Our ref: DOC21/444549-12

Your ref: SSD-9351535

**John Hunter Hospital Health and Innovation Precinct Project (SSD-9351535) – Review of EIS**

Date: 25 June 2021

Figure 11 – Onsite detention basin locations

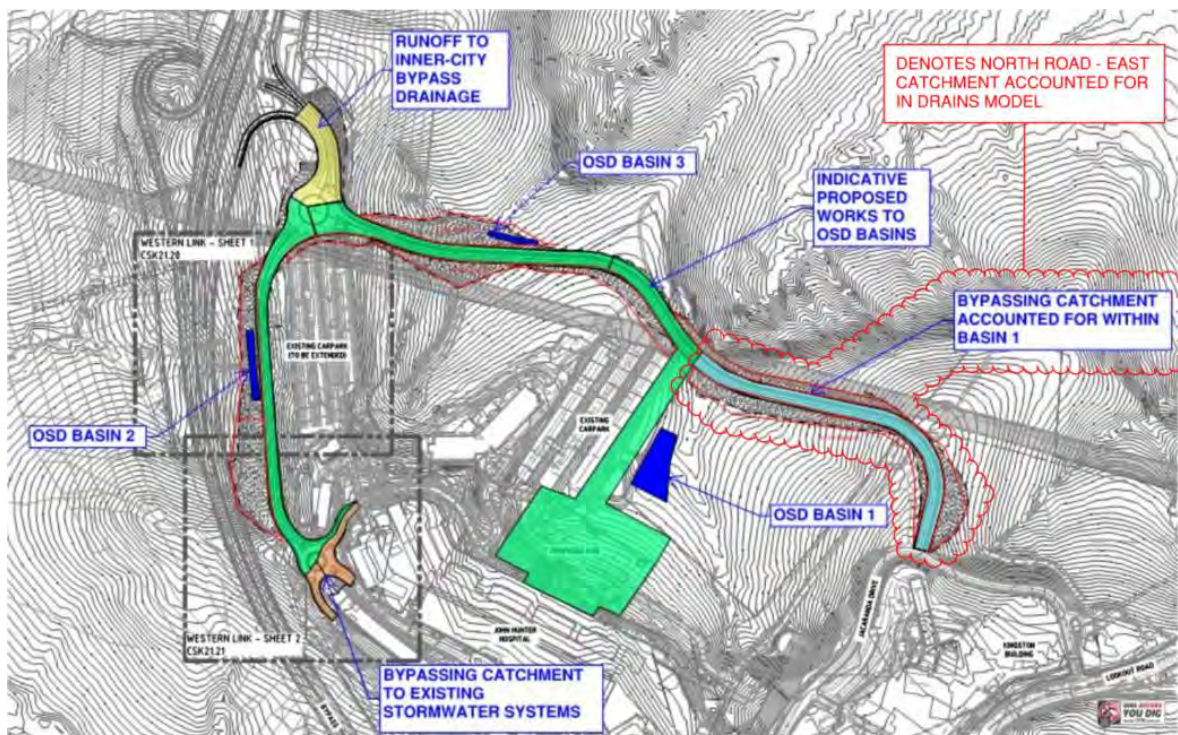
The proposed detention basins have the potential to adversely affect stream erosion by altering the downstream hydrology. The basins are likely to increase the duration of peak flow rates and the volume of discharge. The need for additional stabilisation measures at the detention basin outlets should be investigated further in detailed design.

1. The proponent should assess the potential for stream bank erosion in receiving streams in accordance with the Newcastle DCP Stormwater & Water Efficiency for Development Technical Manual (City of Newcastle 2017).
2. The need for additional scour protection measures at the watercourse crossings should be assessed during detailed design.
